## **Response to Planning Application**

**From:** Arun District Council Greenspace

**Application ref:** WA/63/21/PL

**Description:** Proposed alternative vehicular accesses off Tye Lane and emergency access off Avisford Park Road, along with minor highway works following WA/95/18/RES (resubmission following WA/93/20/PL). This site is CIL Zone 2 (Zero Rated) as other development.

VIEWPORT 1 - PROPOSED RESIDENTIAL ACCESS AT TYE LANE

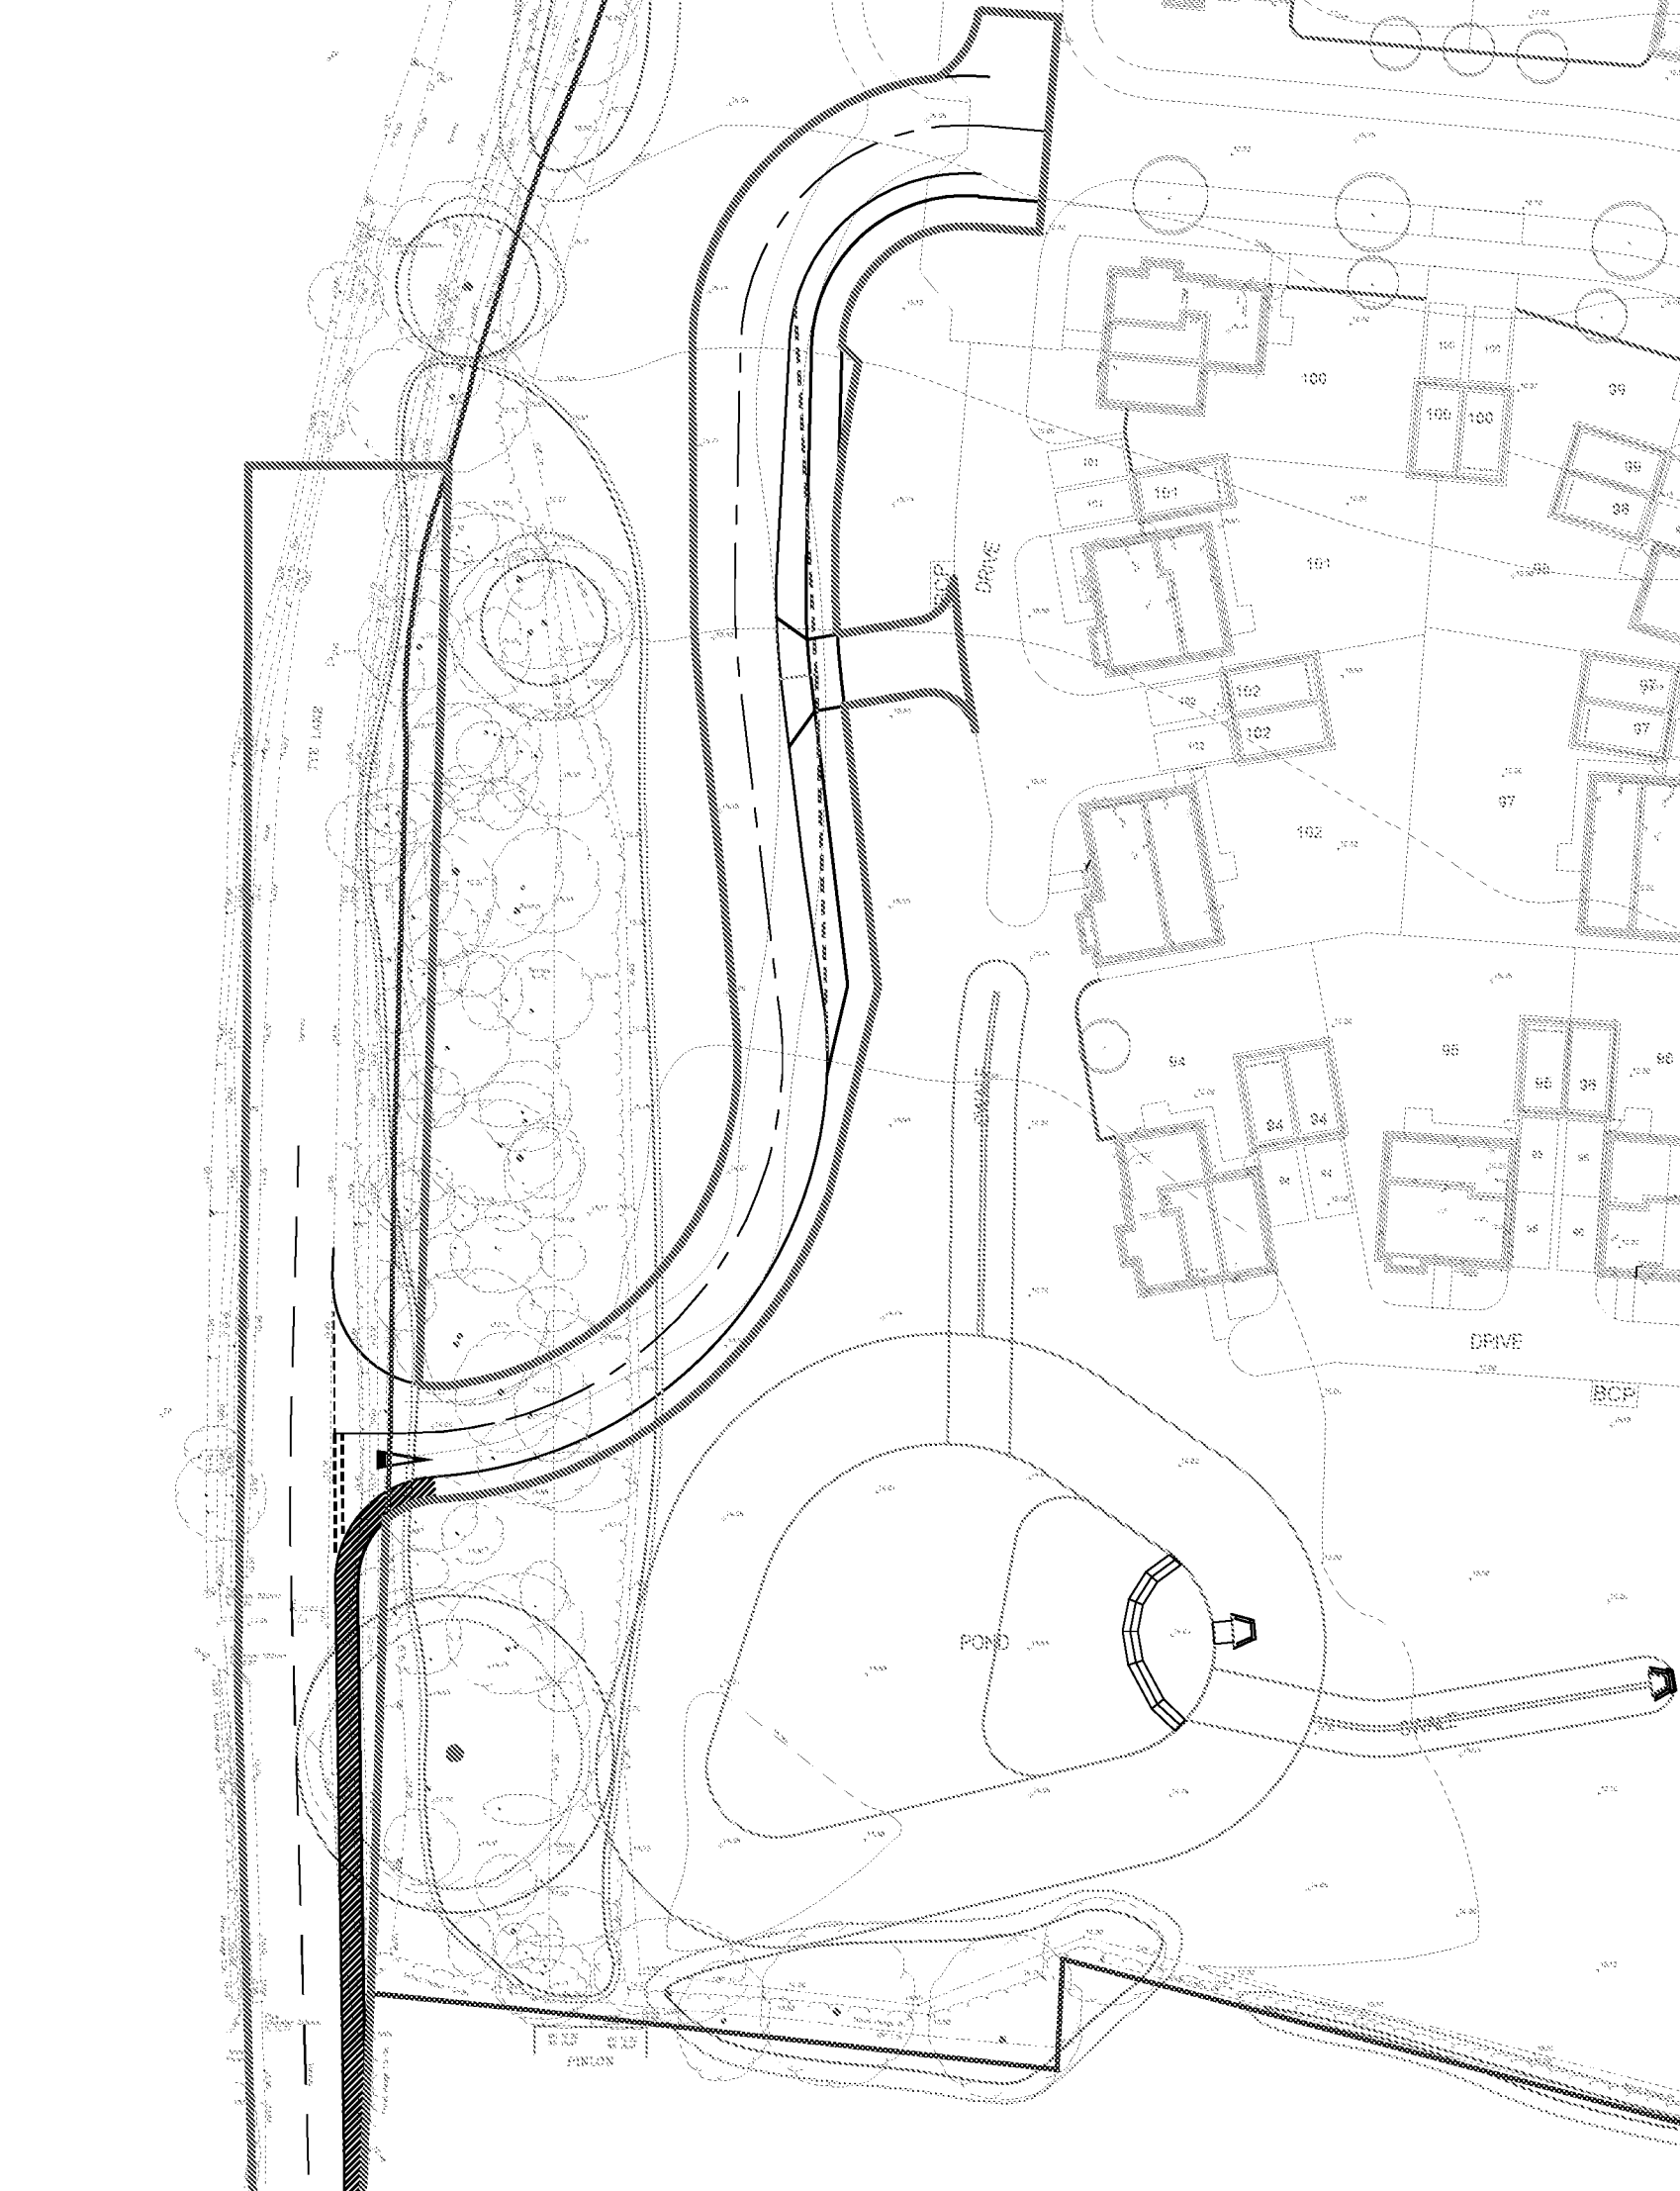
Public Open Space Landscape Proposals Sheet 1 of 4 CSA/3823/107 /Rev Q has proposed alternative vehicular accesses off Tye Lane where an area of existing hedgerow and trees within this site boundary will be effected by the proposals. The actual detail of the proposed removals is still not clear, particularly re proposed tree removals, this information will be required to be submitted for approval by the LPA Tree Officer. Landscape mitigation and replanting to this proposed entrance will need to be submitted for approval.

Additional landscape provision will be required once the extent of the required removals is known. Additional protection will be required to the adjacent trees and hedges which are to remain in this area and whose canopy and root protection areas will fall within the construction area of these proposals. The green boundary treatment and mitigation to counteract the proposed loss along this entrance boundary will need to include tree and shrub species, suitable to enhance and blend with the existing species mix in this location. Biodiversity and habitat connection will need to be a consideration of any mitigation proposals. Mitigation planting should be at a size which provides instant gains and which will aid recovery of the impacted area in the shortest possible time, but which will also establish and mature as the site develops.

VIEWPORT 2 - PROPOSED EMERGENCY ACCESS AT AVISFOD PARK ROAD

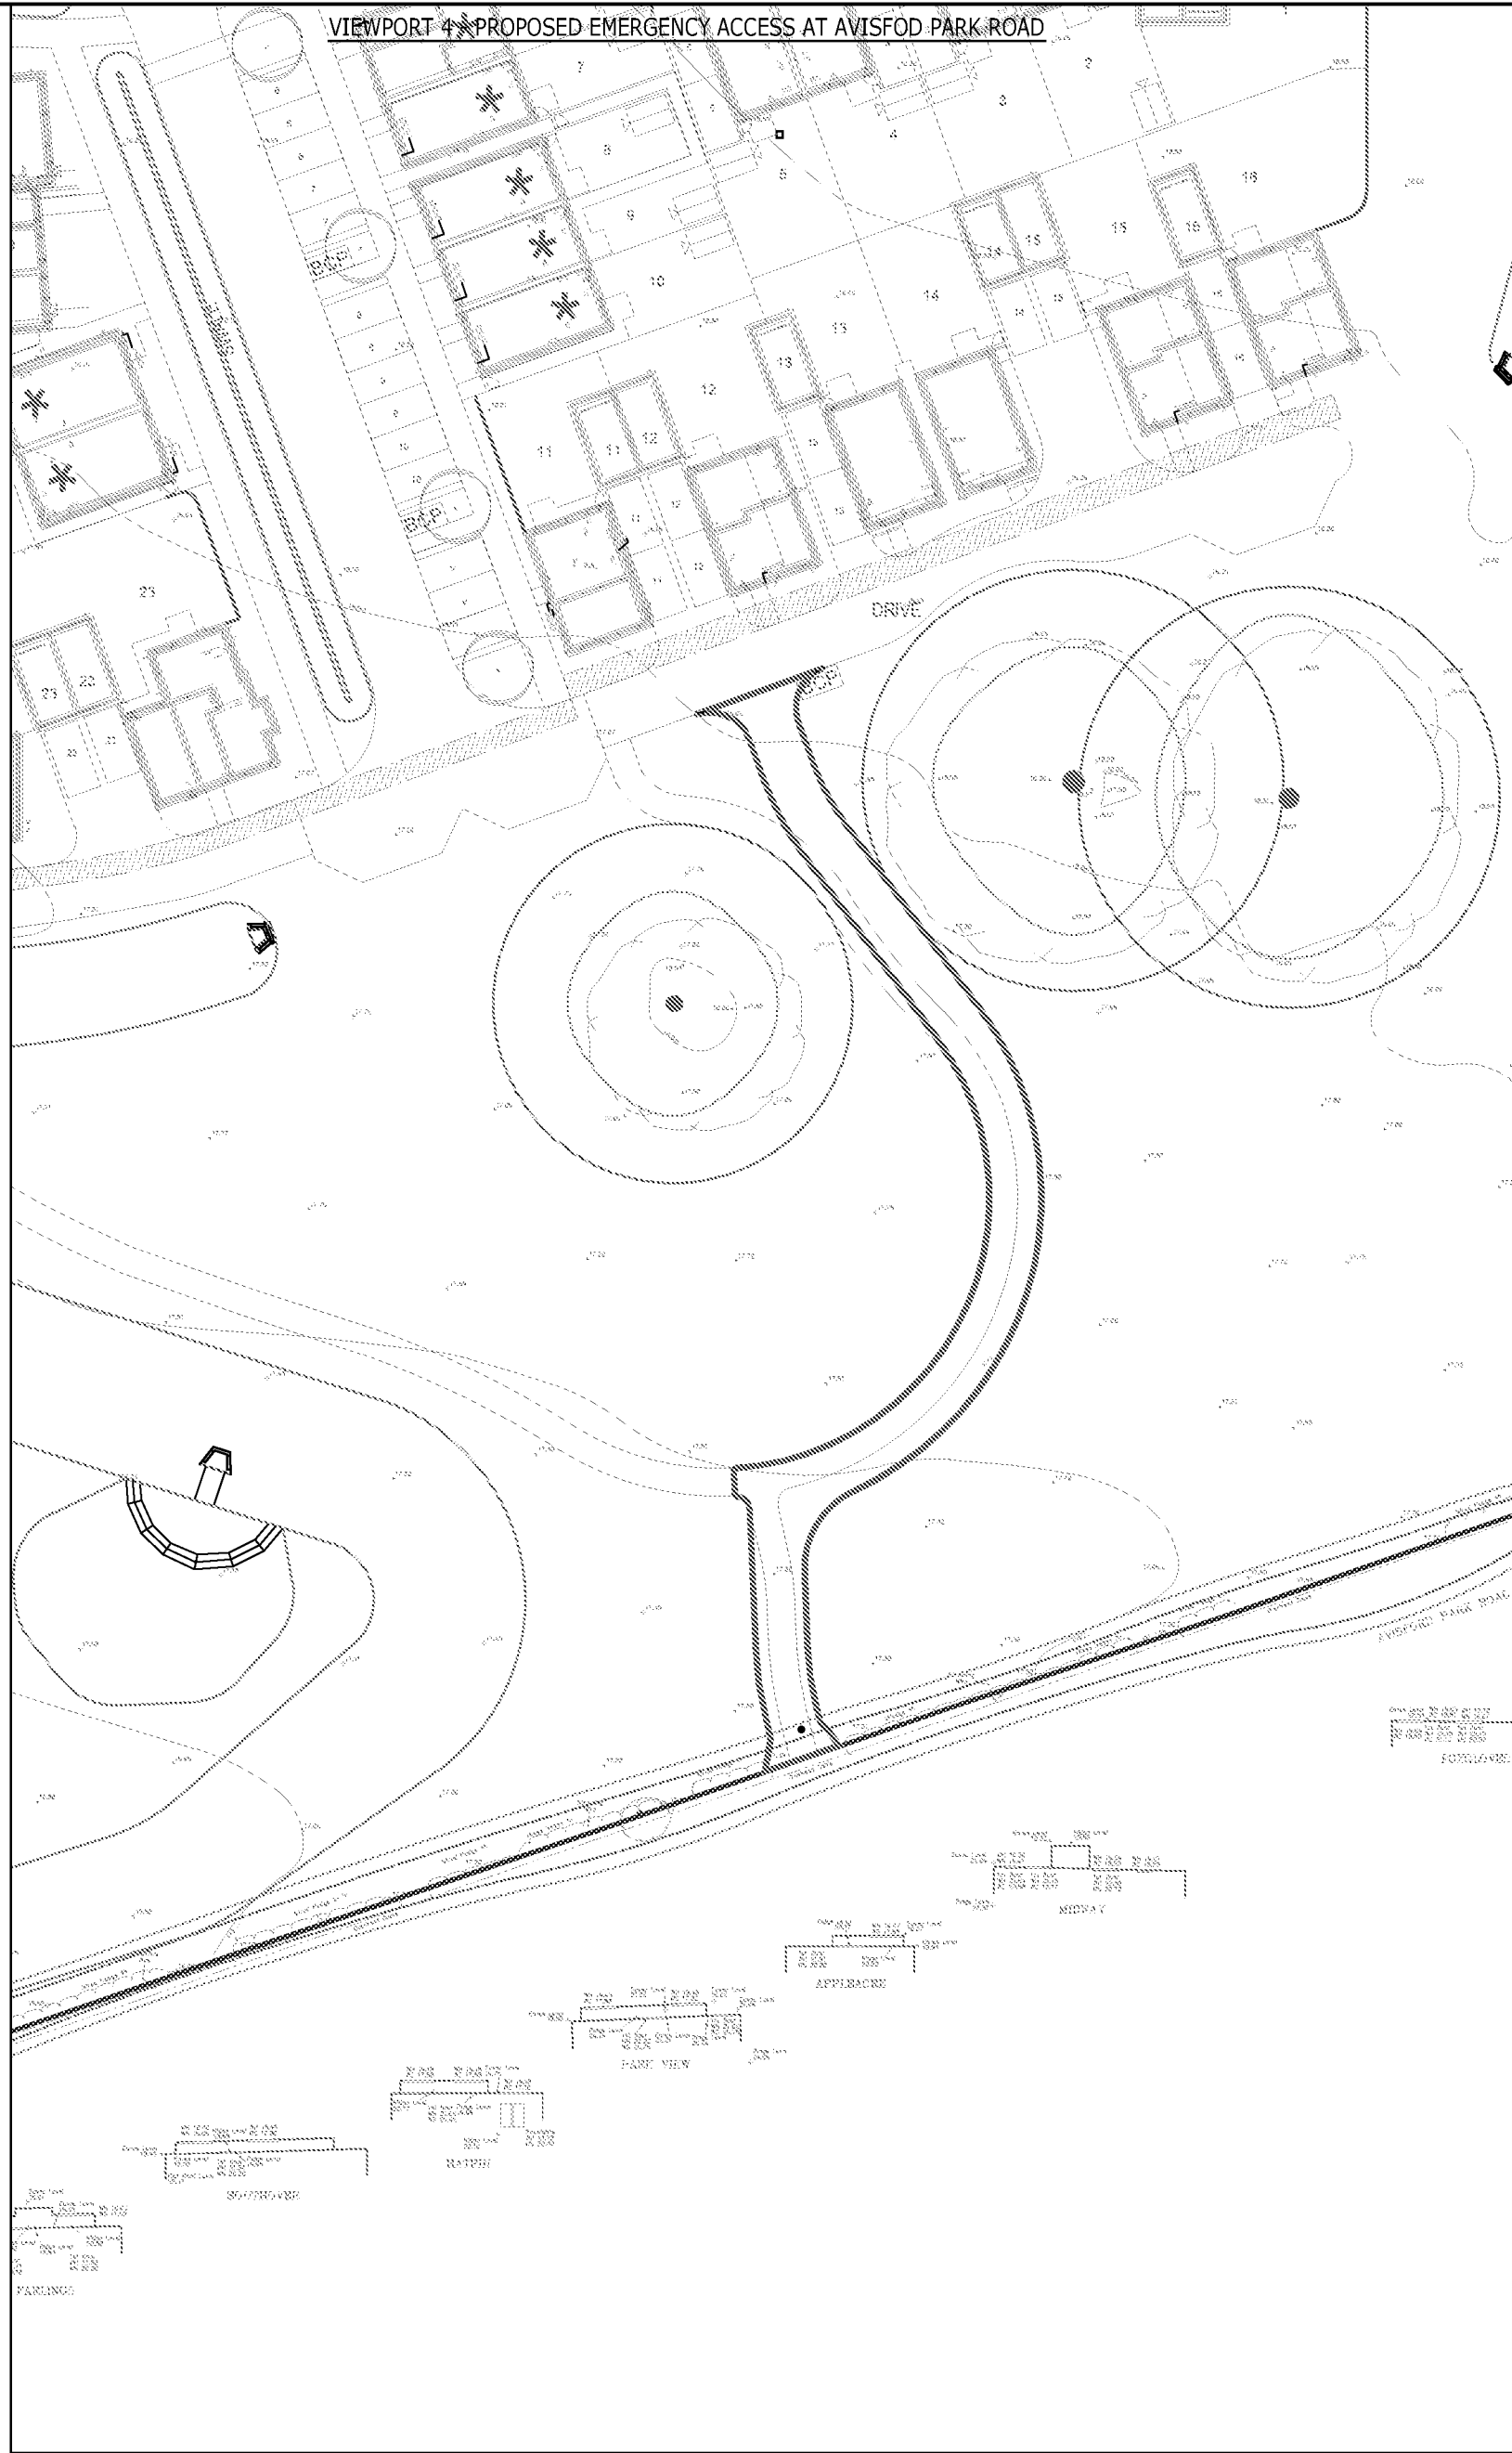
Public Open Space Landscape Proposals Sheet 3 of 4 CSA/3823/109/Rev P details the emergency access off Avisford Park Road. This connection into and through the site is not ideal with routing through a key area of POS, the community orchard and passing adjacent to the LAP. Recommendation would be that this road is subject to restricted access for emergency access only and should not be considered for any other access purposes. In addition it should be imposed that knee rail fencing is now included along the LAP edge which borders this roadway.

Recommend that mitigation planting be required for any green infrastructure removal transpiring from these proposed alternative vehicular accesses proposals. Recommend that the LAP area receive knee rail fencing along the edge which borders the proposed emergency Avisford Park access road.
